Mr Brad Campbell
Bursar
Sydney Grammar School
10-12 College Street
Darlinghurst NSW 2010
21/12/2020

**Weigall Sports Complex, Sydney Grammar School (SSD-10421)
Response to Submissions**

ATTACHMENT 1

3 21/06 11 00 AM

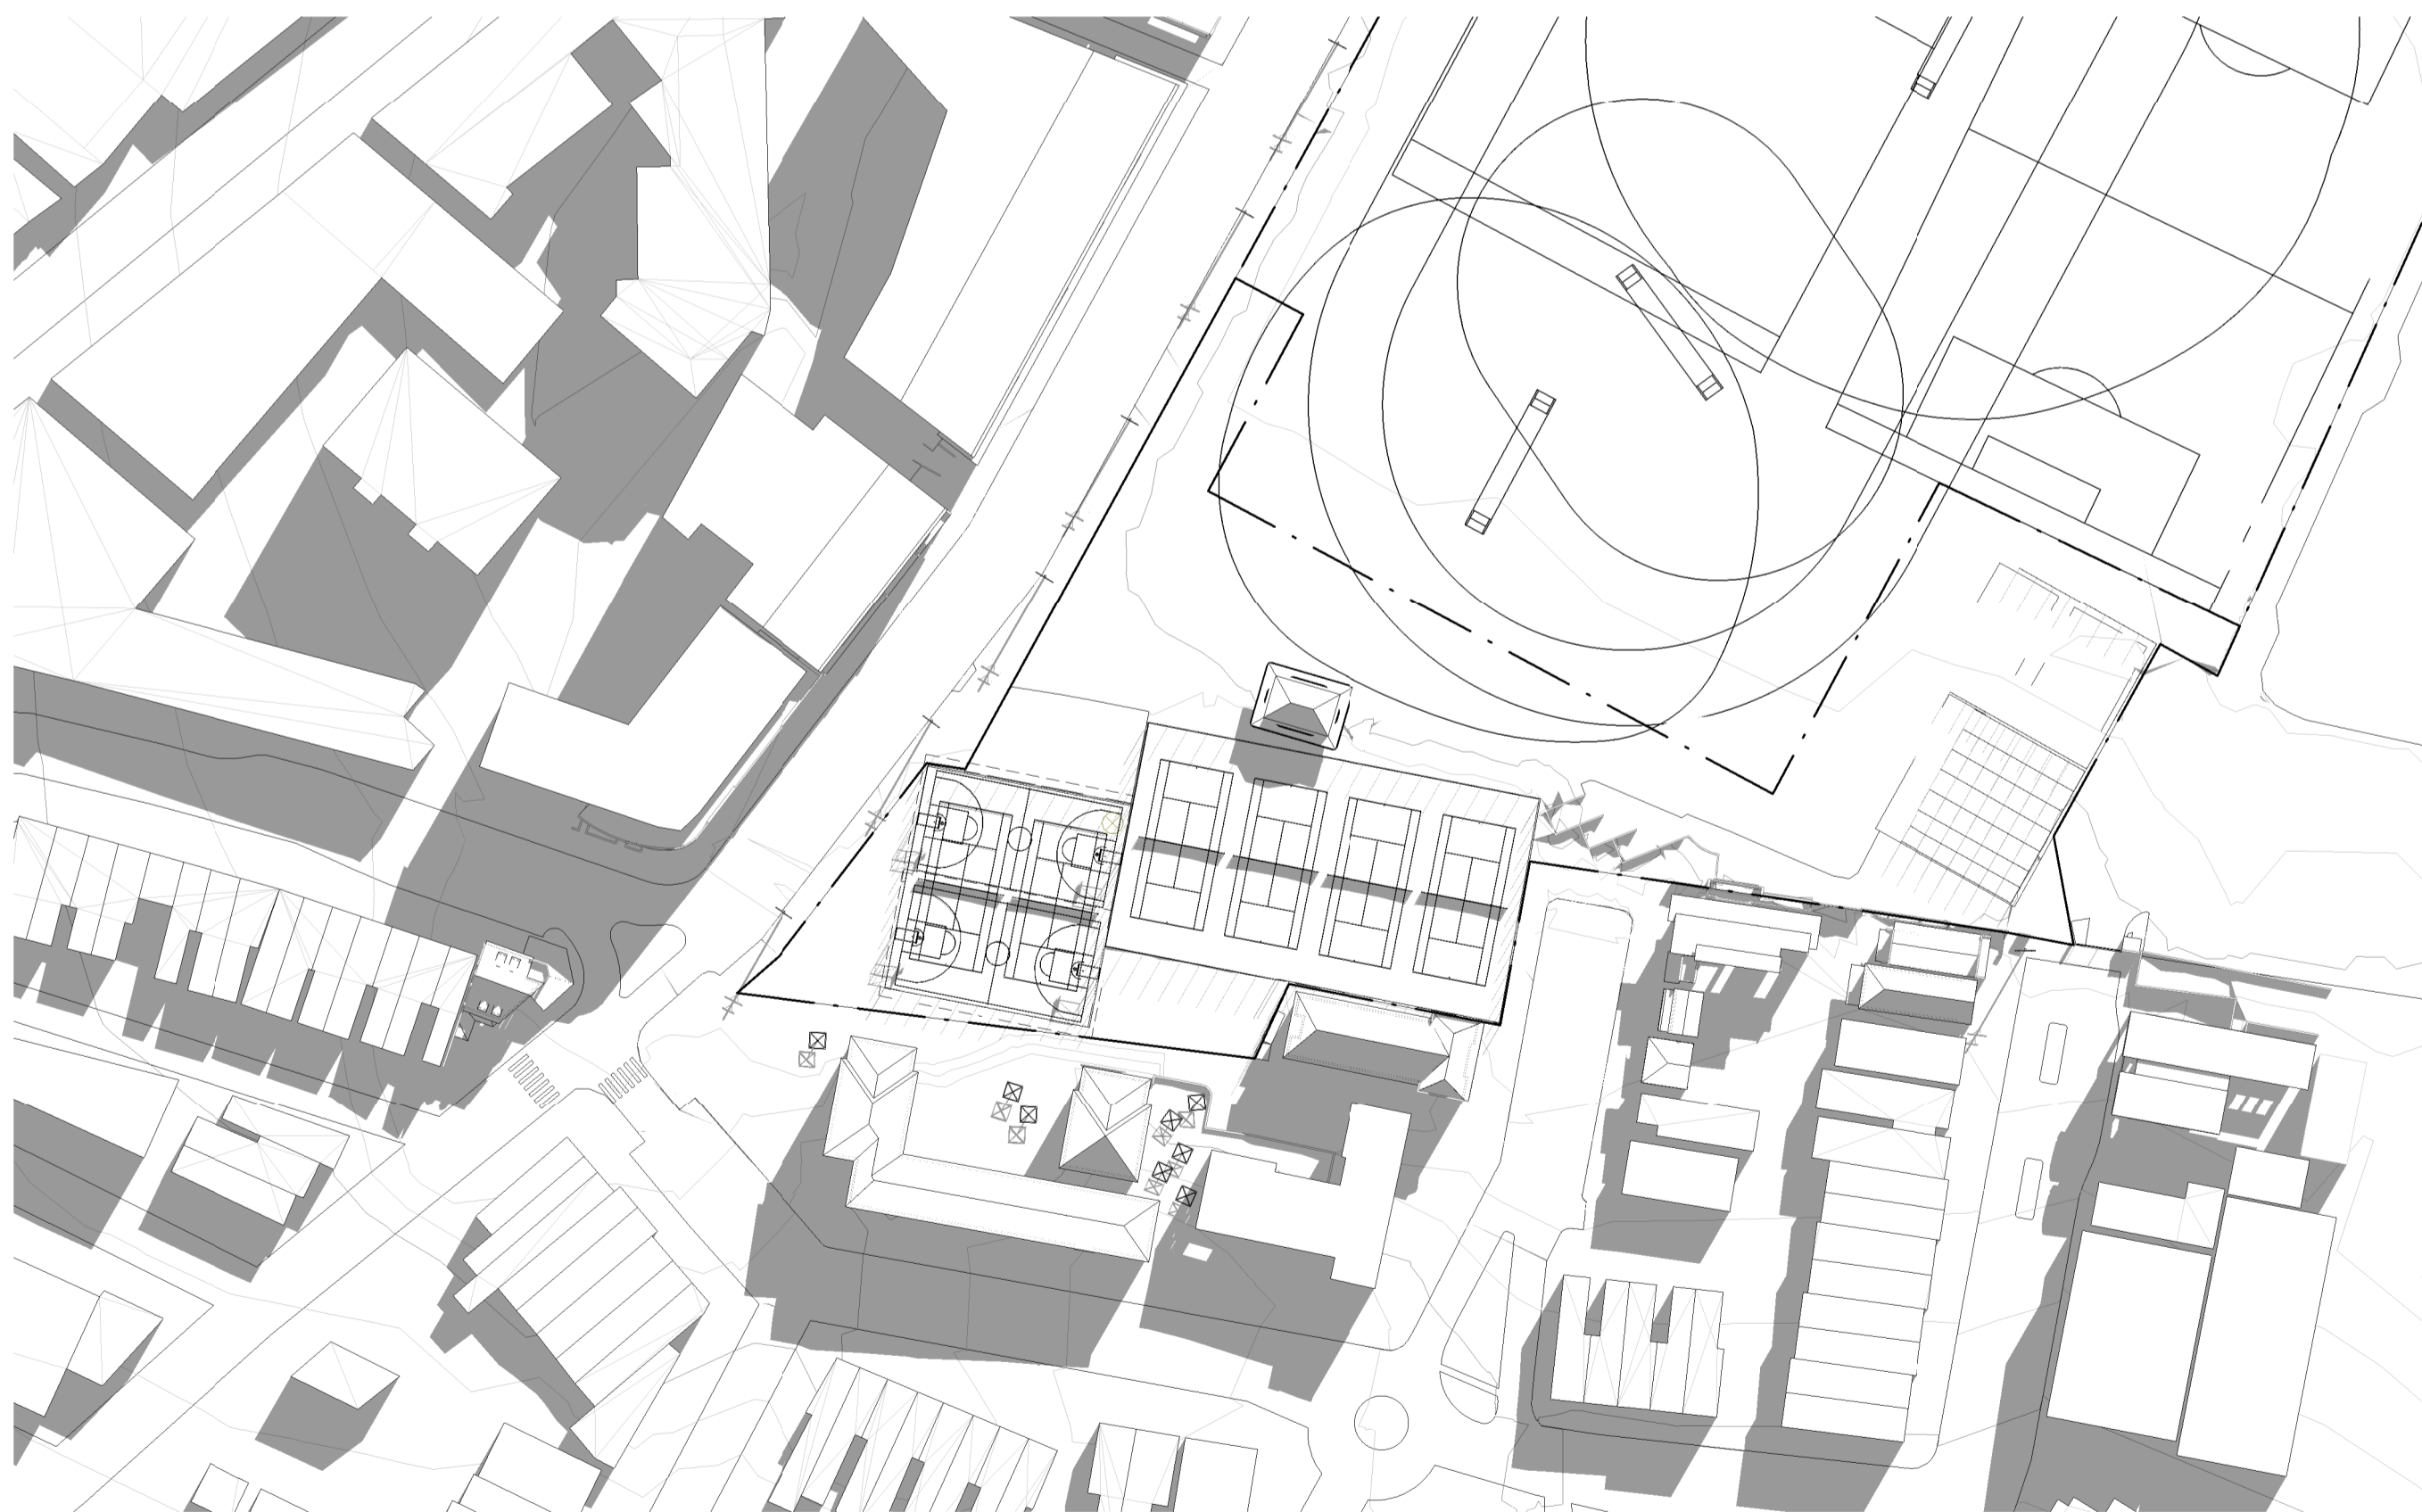
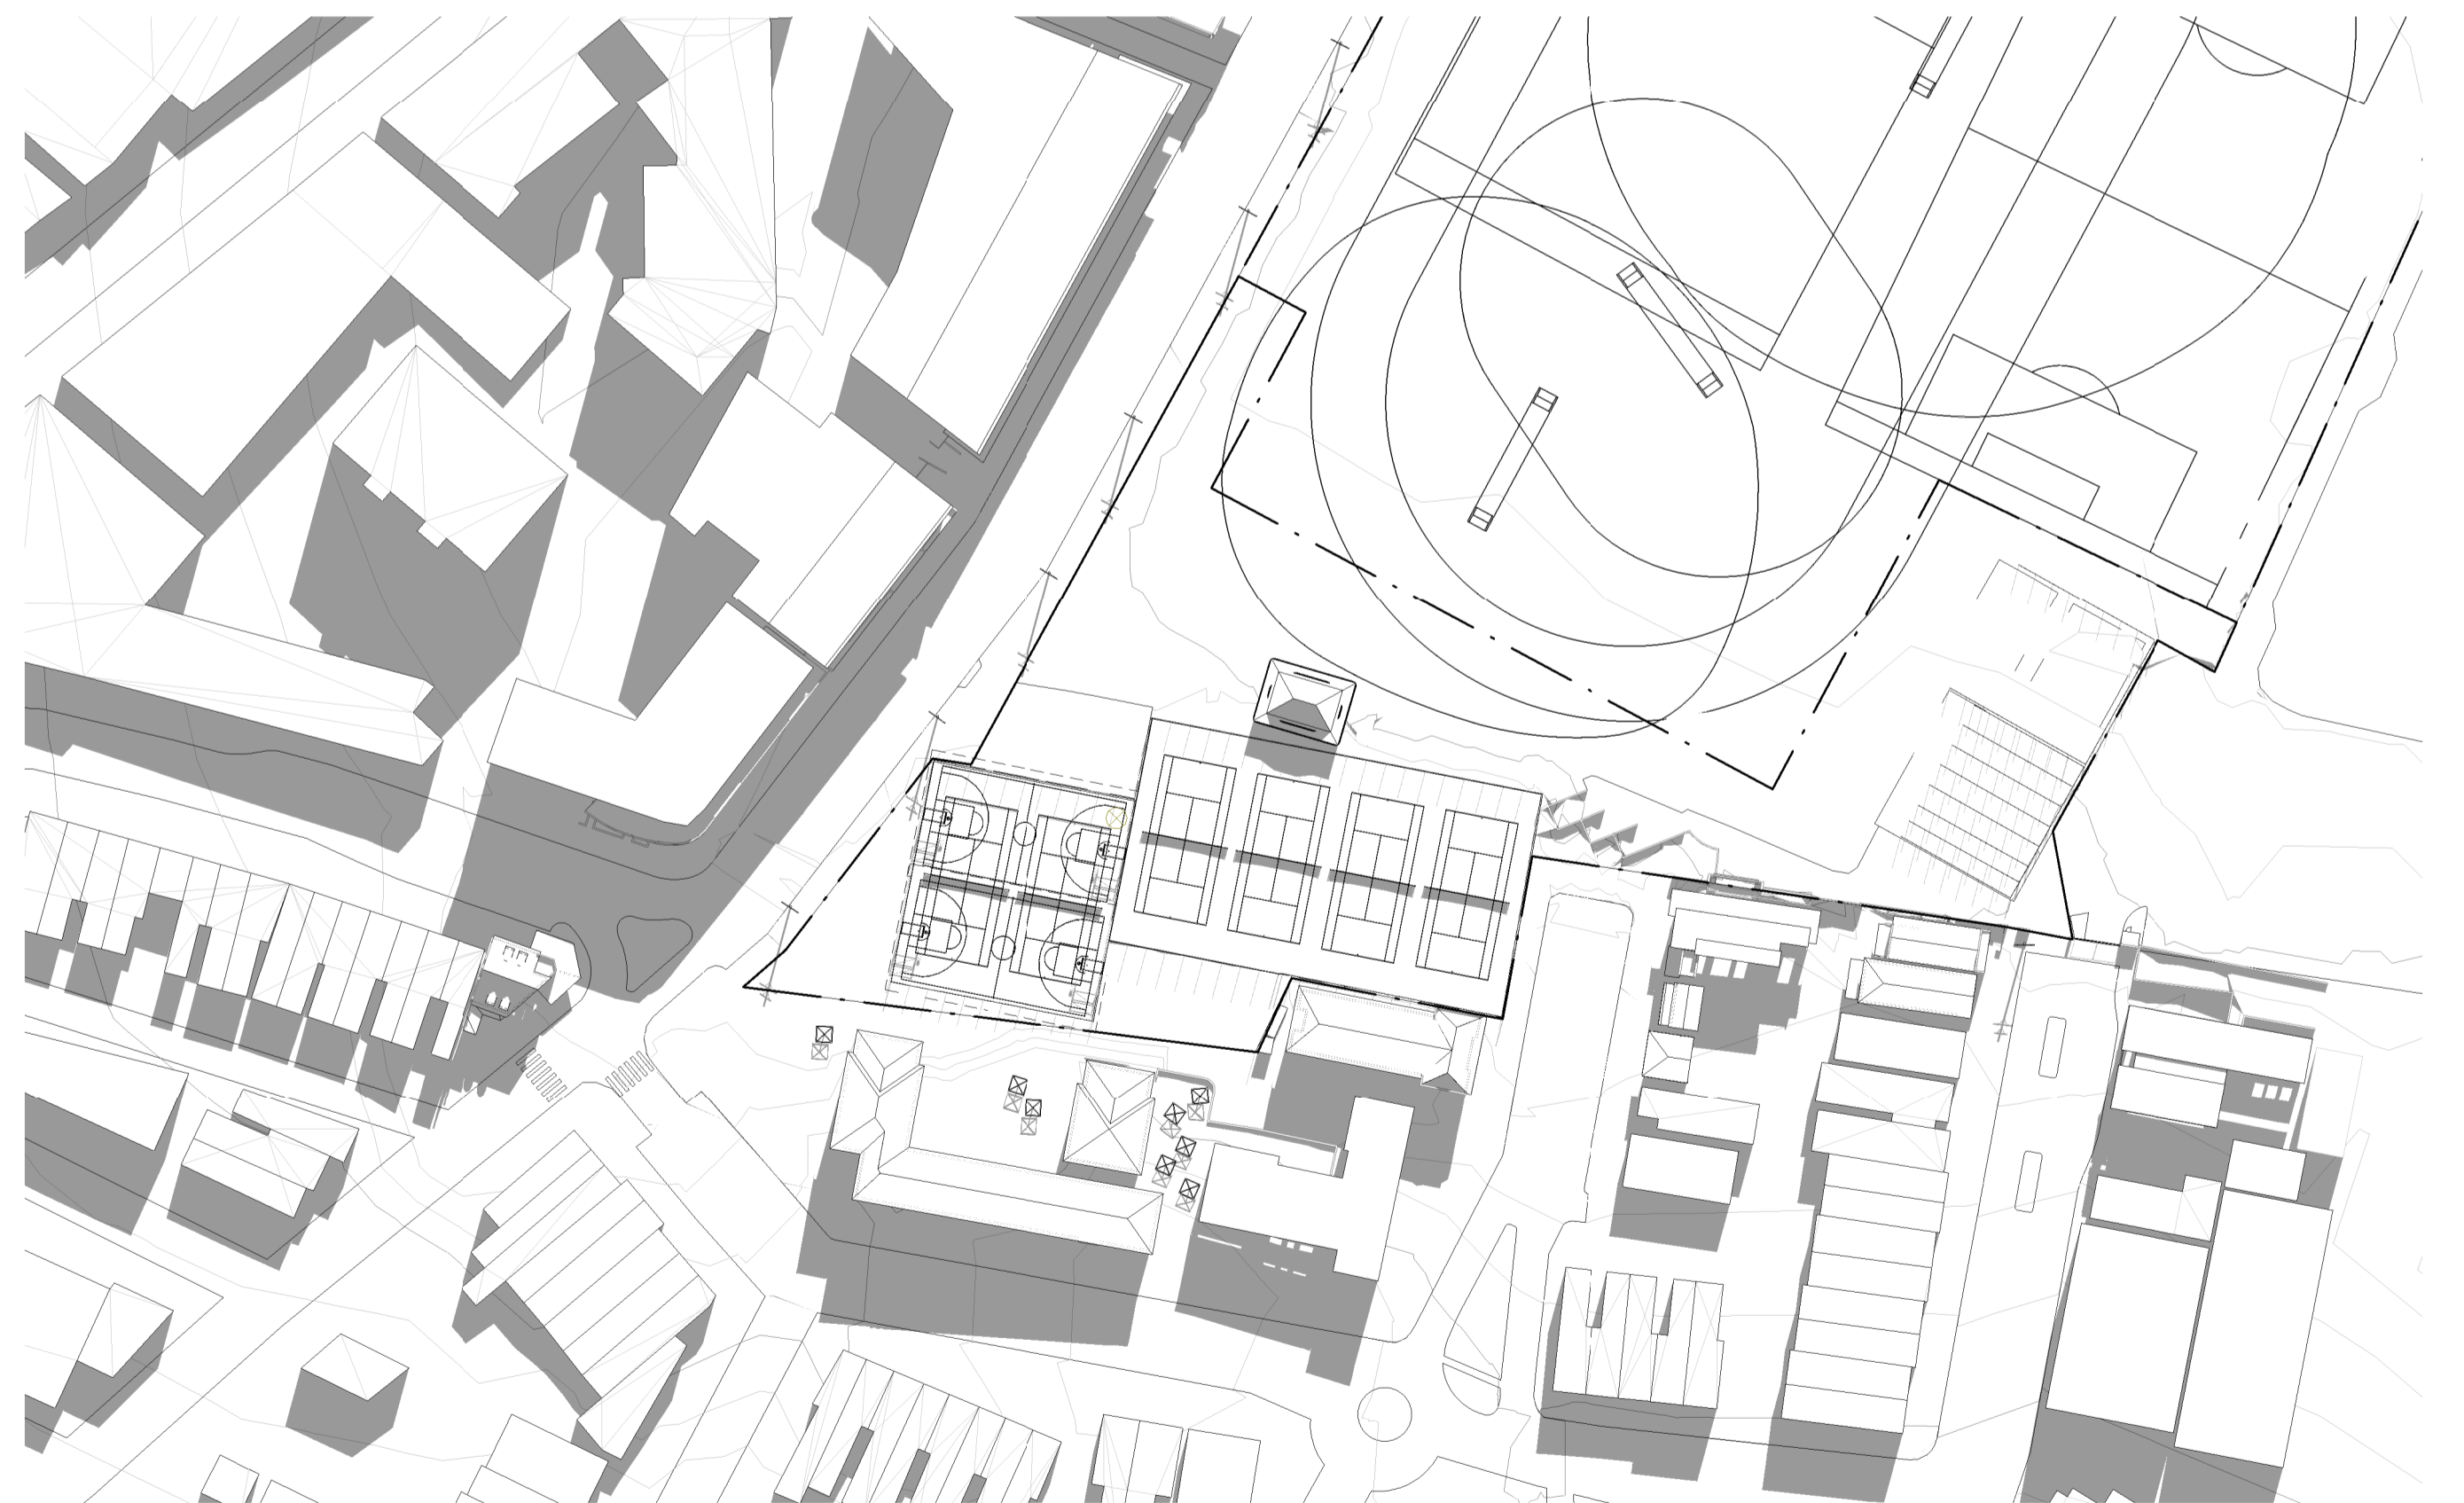
- a) details to demonstrate how the proposed development addresses the visual privacy requirements under ADG with respect to the adjoining RFB to the south. A detailed table of compliance with the separation distances should be included for each of the dwelling units/rooms fronting the proposed development.
- b) hourly shadow diagrams (both elevation and plan view and a schedule with the unit numbers) to demonstrate the total number of hours the dwelling units located along the southern boundary would receive sunlight between 9am – 3pm during winter solstice.
